**KIRKLEES METROPOLITAN COUNCIL  
INVESTMENT & REGENERATION SERVICE**

**DELEGATED DECISION TO DETERMINE PLANNING APPLICATIONS**

Reference No:	<b>2024/62/93571/W</b>
Site Address:	14, Smithy Close, Lindley, Huddersfield, HD3 3ZB
Description:	Demolition of existing garage and erection of detached garage and alterations to existing dwelling
Recommending Officer:	Joanna Rednall

**DECISION – CONDITIONAL FULL PERMISSION**

**Proposed Elevations**

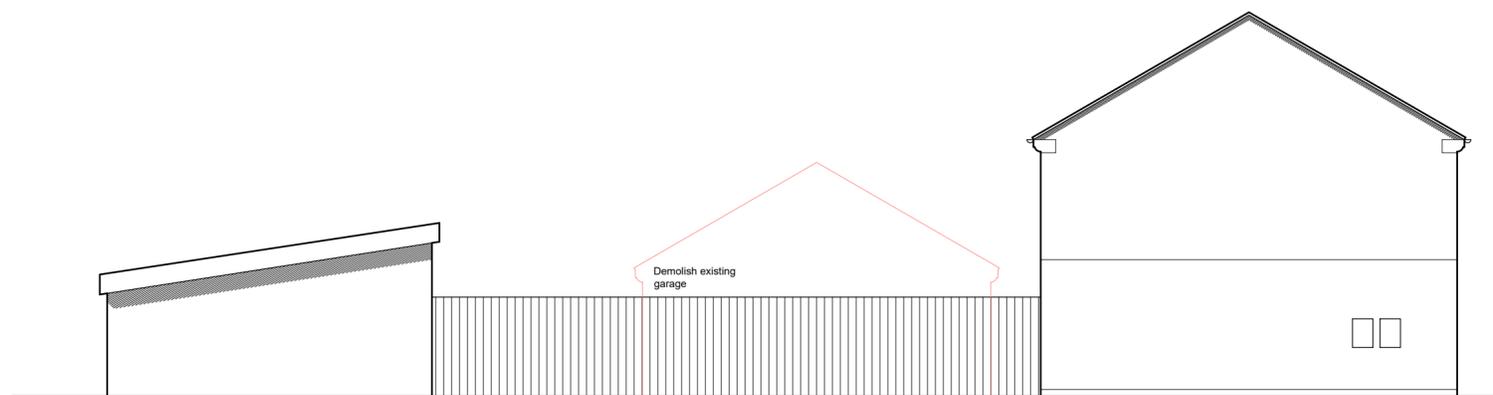
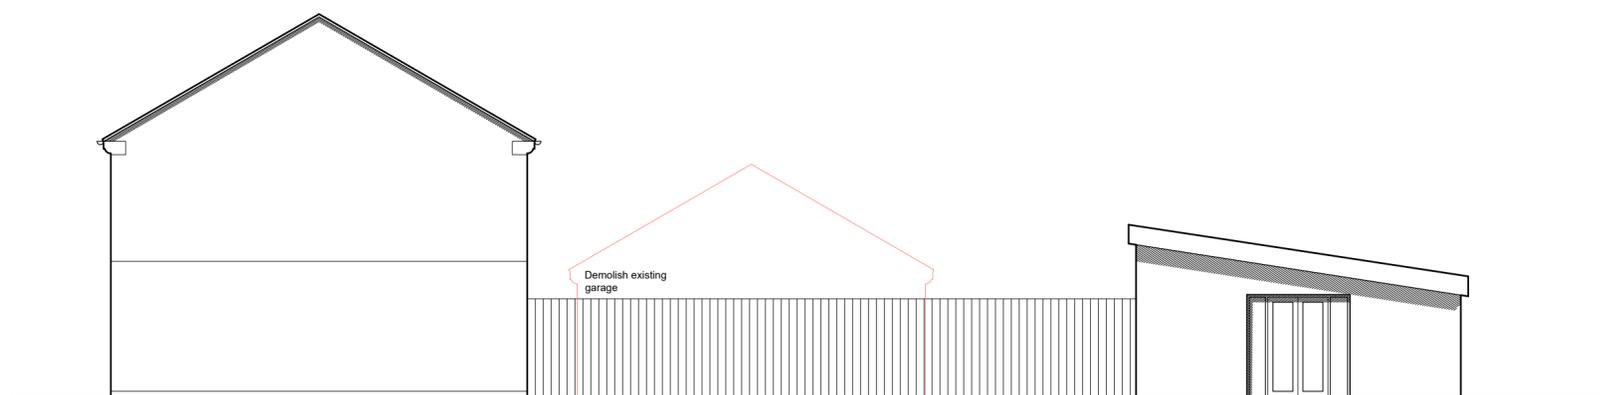
The existing garage measuring approximately 7 metres in depth, 3.1 metres in width and a total height of 4.7 metres would be demolished to facilitate the proposed detached garage. This garage is proposed to the rear garden and would measure approximately 6.5 metres in depth, 6.5 metres in width, 2.1 metre eave height and 3.5 metres in total height.

The garage would be finished in stone with a concrete tile roof, upvc openings to the east-facing elevation and a roller-shutter door to the south-facing elevation.

The development would result in a degree of bulking and massing closer to the common boundaries, any harmful impacts are mitigated by the structures limited height. The submitted elevations show no openings are proposed to the elevations facing No.15 and 11, therefore the development would not result in a significant loss of privacy to the occupants of these dwellings.

Updated plans were provided to correct discrepancies in the proposed elevation measurements.
